From: adam kahan 
Sent: 19 September 2018 13:22
To: Zac Denton; Planning
Subject: R/188/18/HH objection

R/188/18/HH

I wish to object to this planning application because a) the application is factually incorrect both in the answers to questions on the form and the drawings submitted b) it breaches multiple Arun and Rustington policies.

PROPOSED FLOOR PLANS, ELEVATIONS,
ROOF PLAN & BLOCK
81 Sea Avenue
Rustington
West Sussex
BN16 2DR

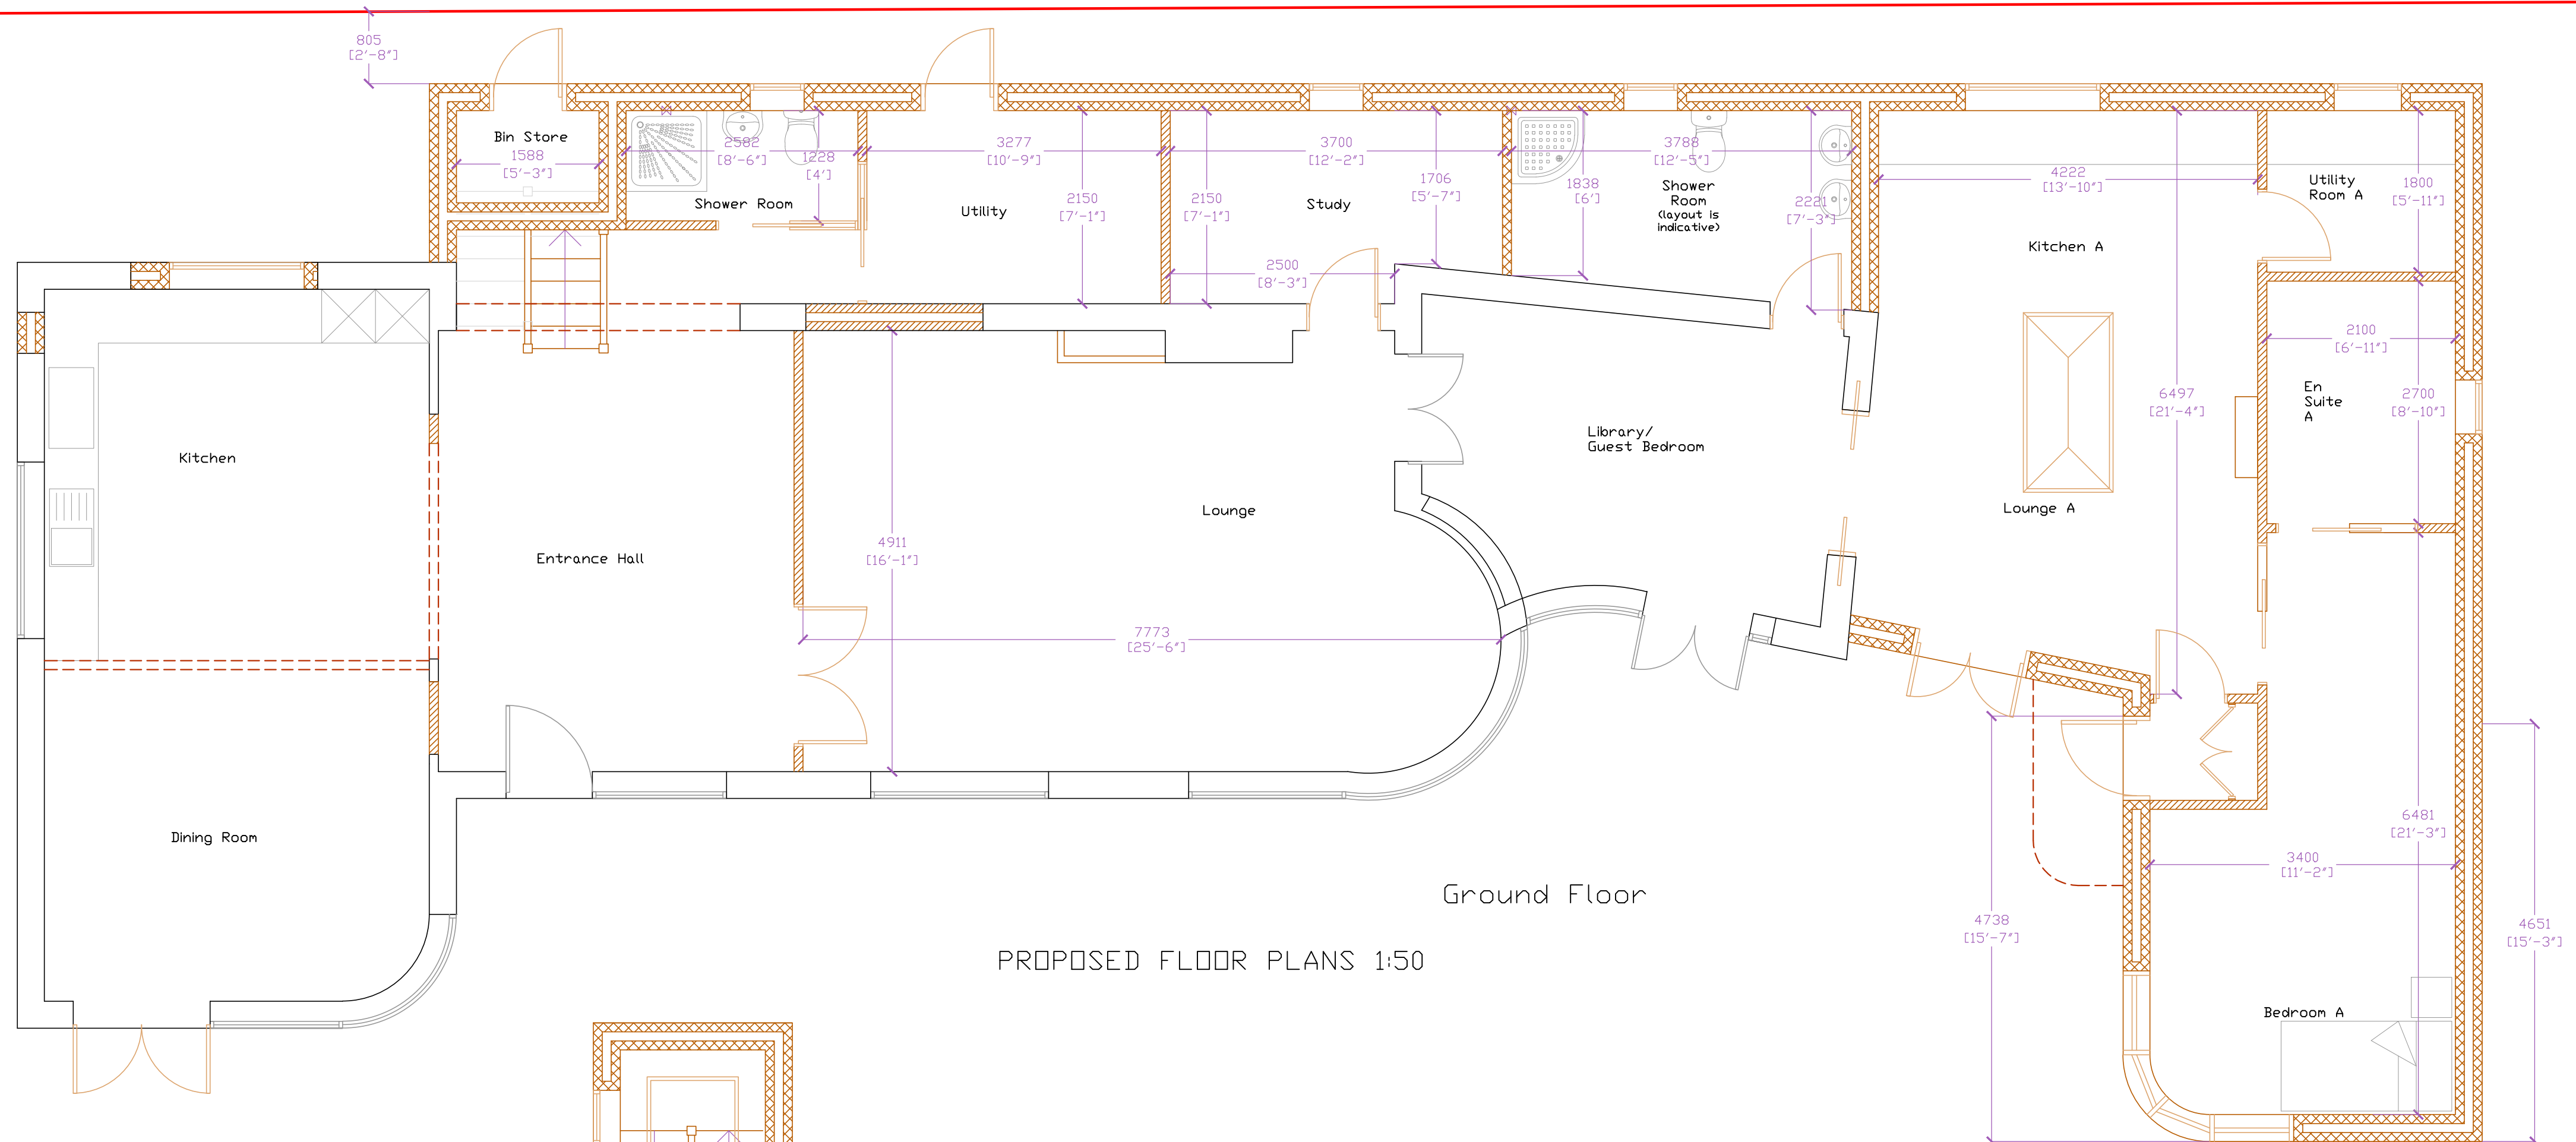
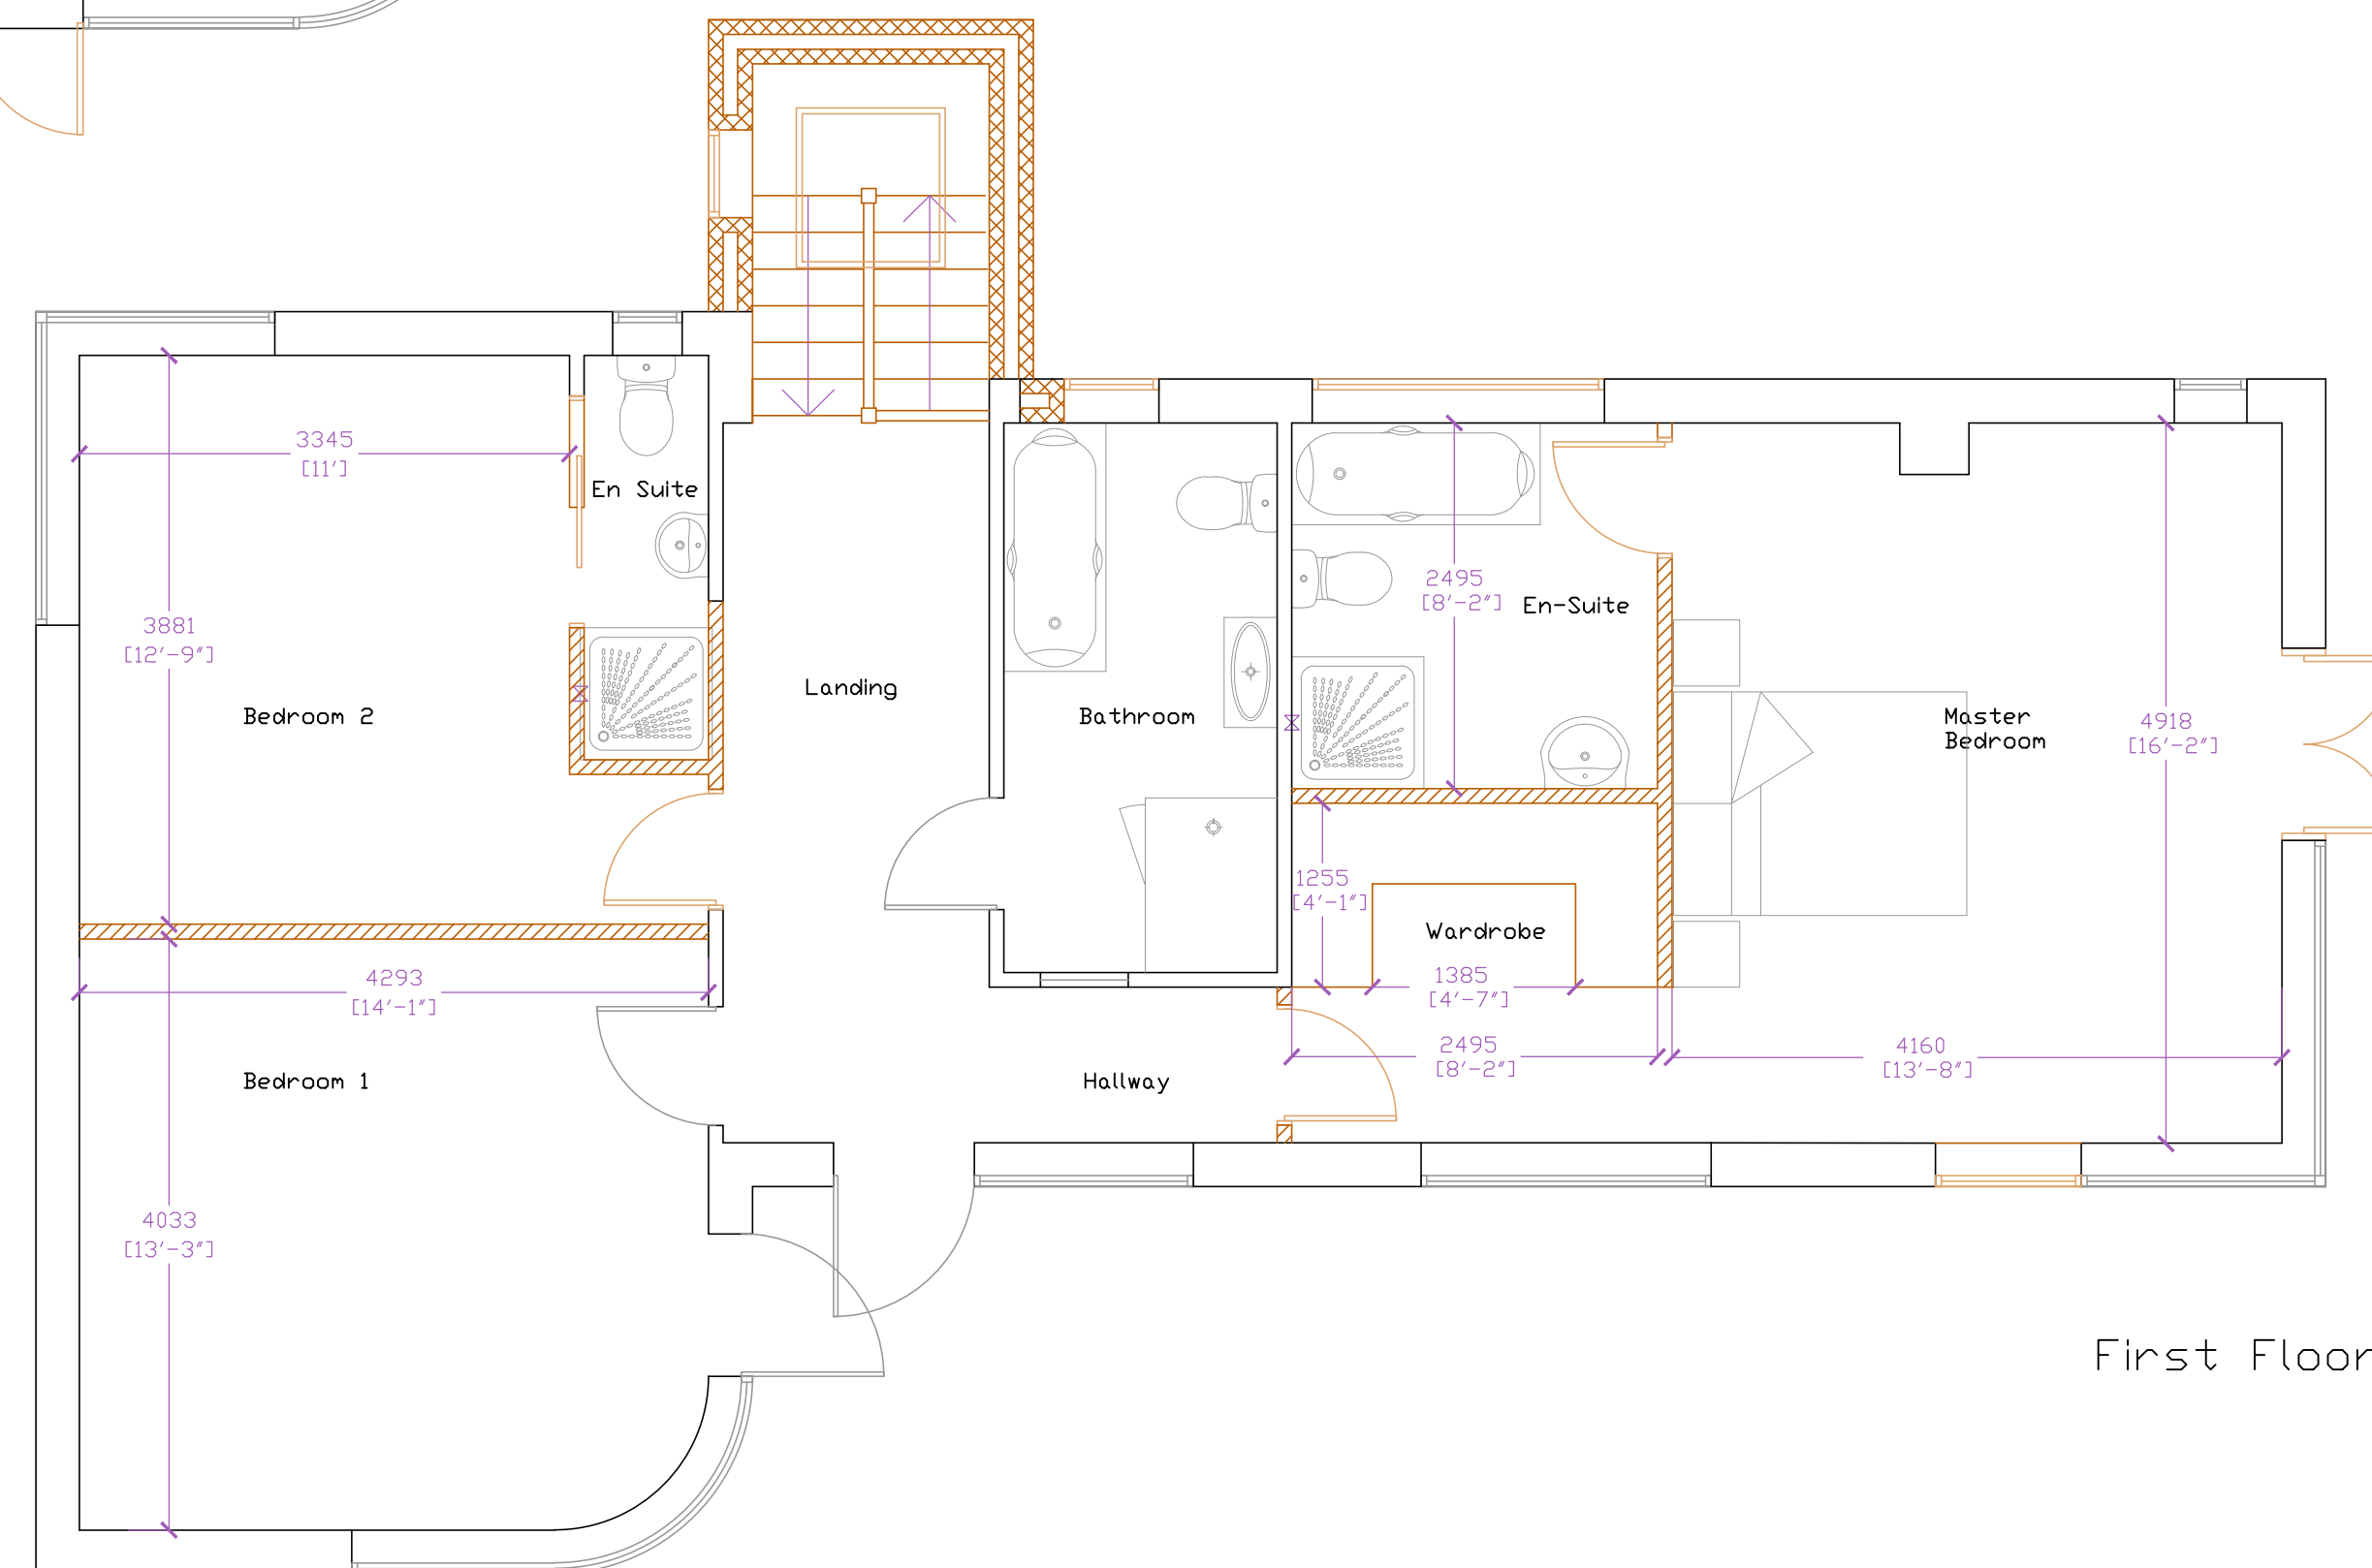
5. **SCALE AND MASS** The extension and annexe will increase the ground footprint of the property by 80%, far in excess of the specific 50% limit in Arun Local Plan section 13.4.4. The annexe effectively creates a new four roomed bungalow

BLOCK 1:500

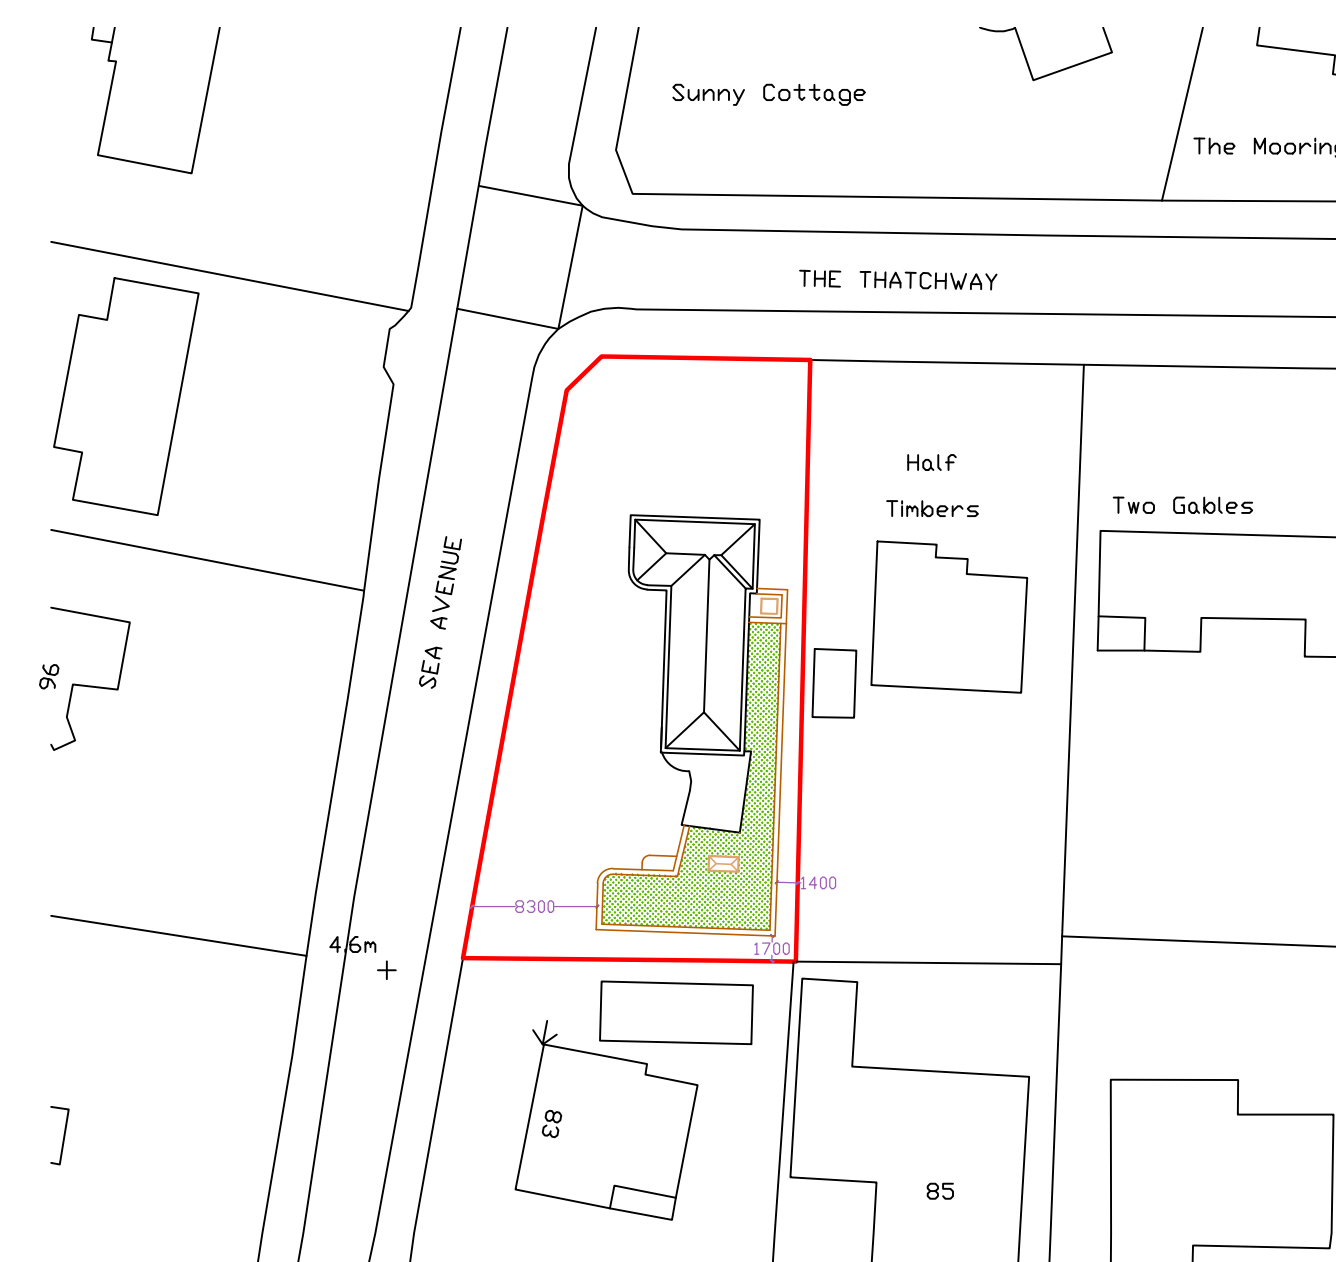
3. **BOUNDARY DISTANCE** The application shows that the extension would be 0.805m from the side boundary. This breaches Policy D DM4d, which requires a minimum of 1m to the boundary.
